Addendum No. 1

RE: Contract # C204149

Halifax County (R-3822, U-5725)

NC-125 From I-95 To Old Farm Road South; SR-1627 (Three Bridge Road)

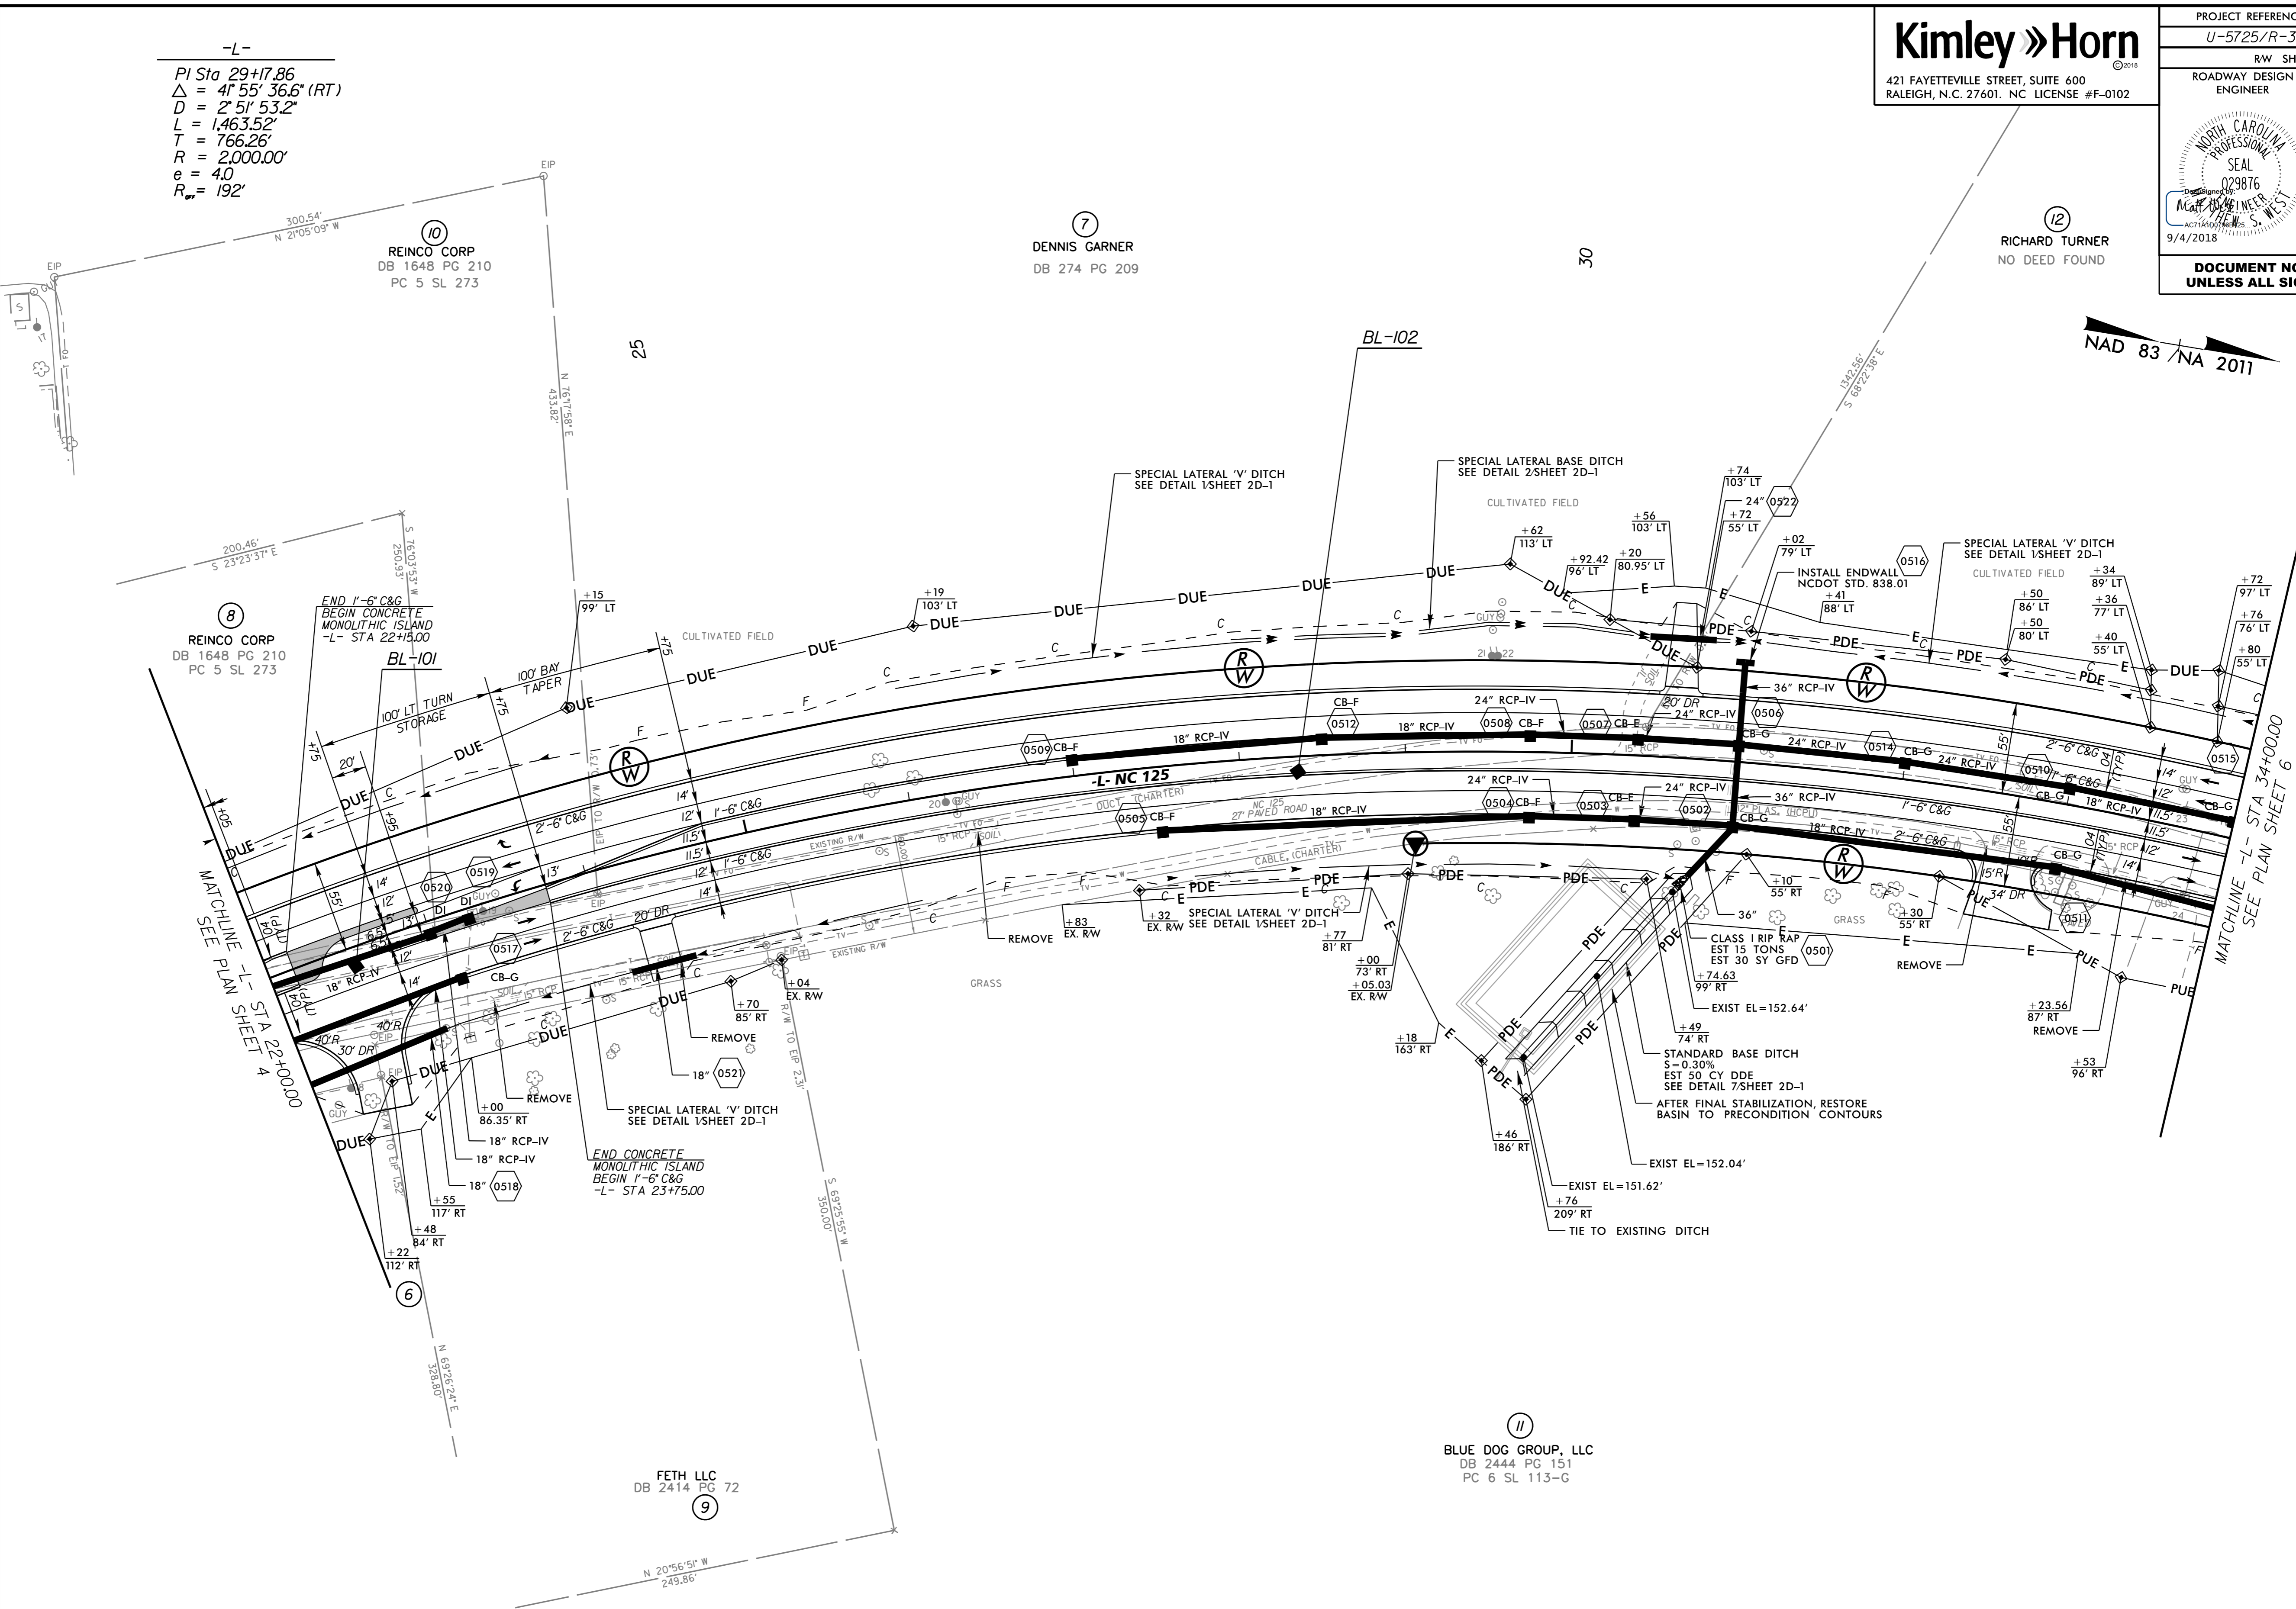
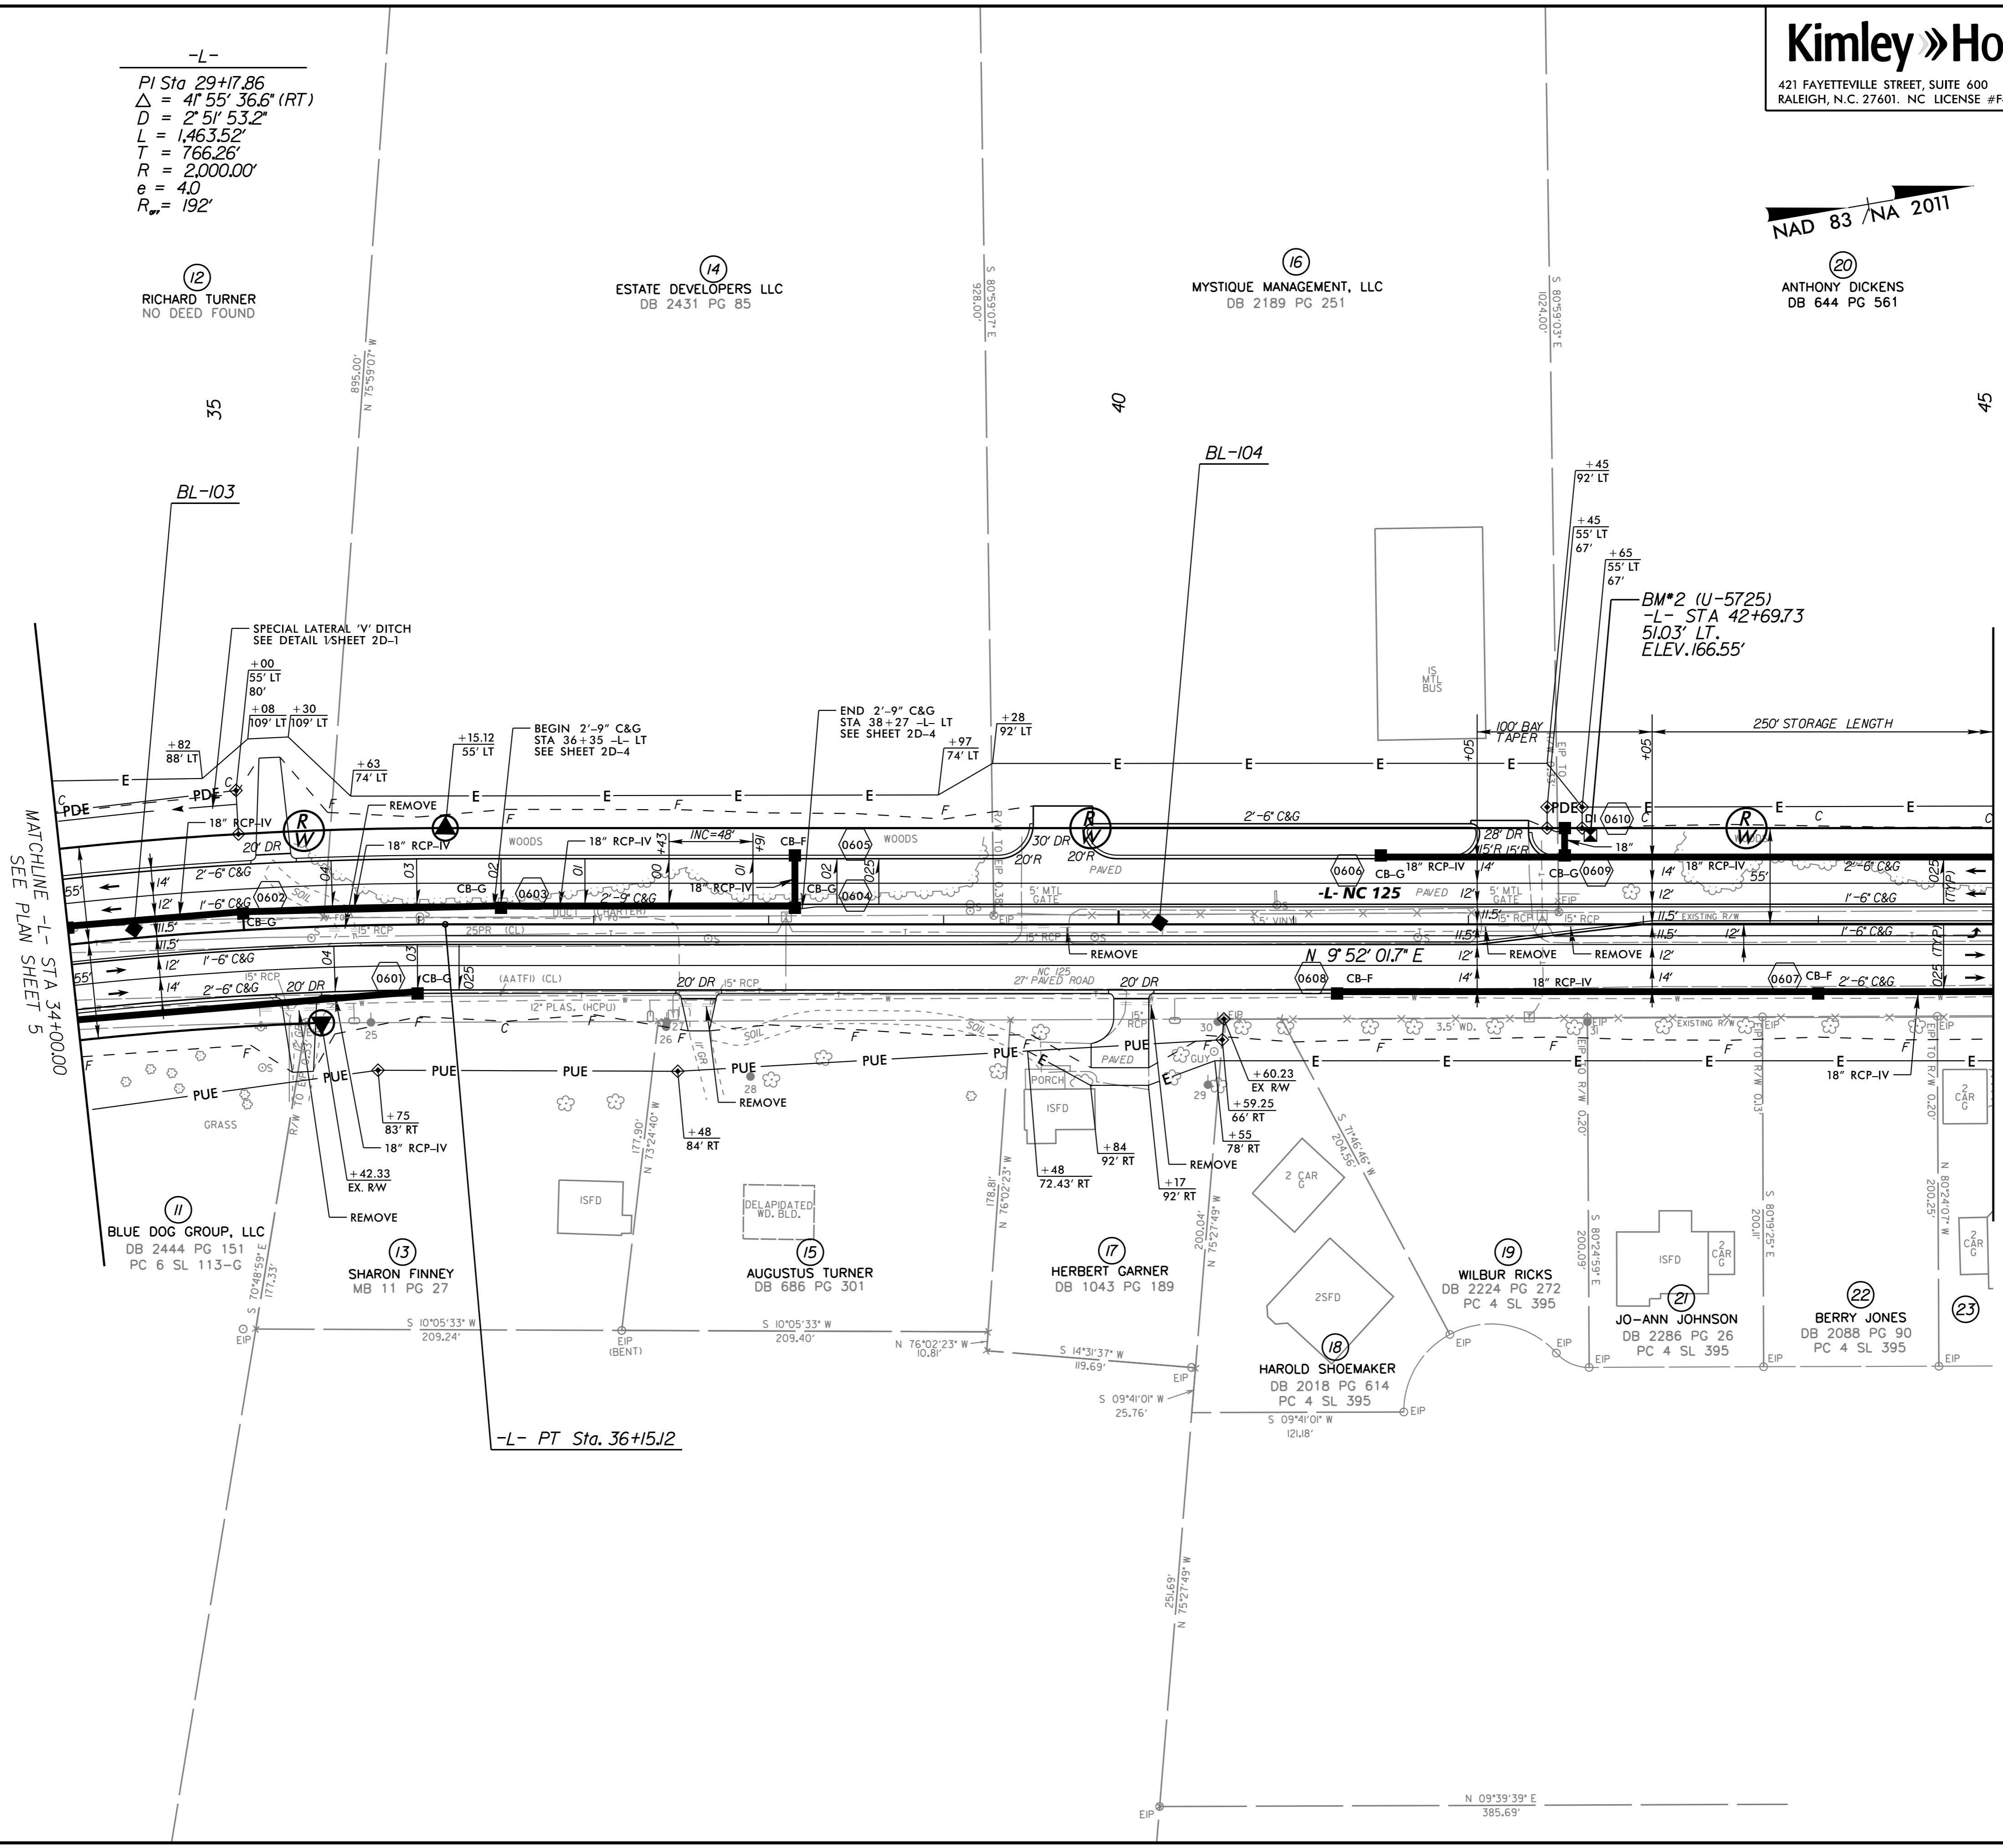
Sheet No.	Revisions
4 thru 19	Revised Right of Way and Easement notes for some callouts. Right of Way and easement lines have not changed
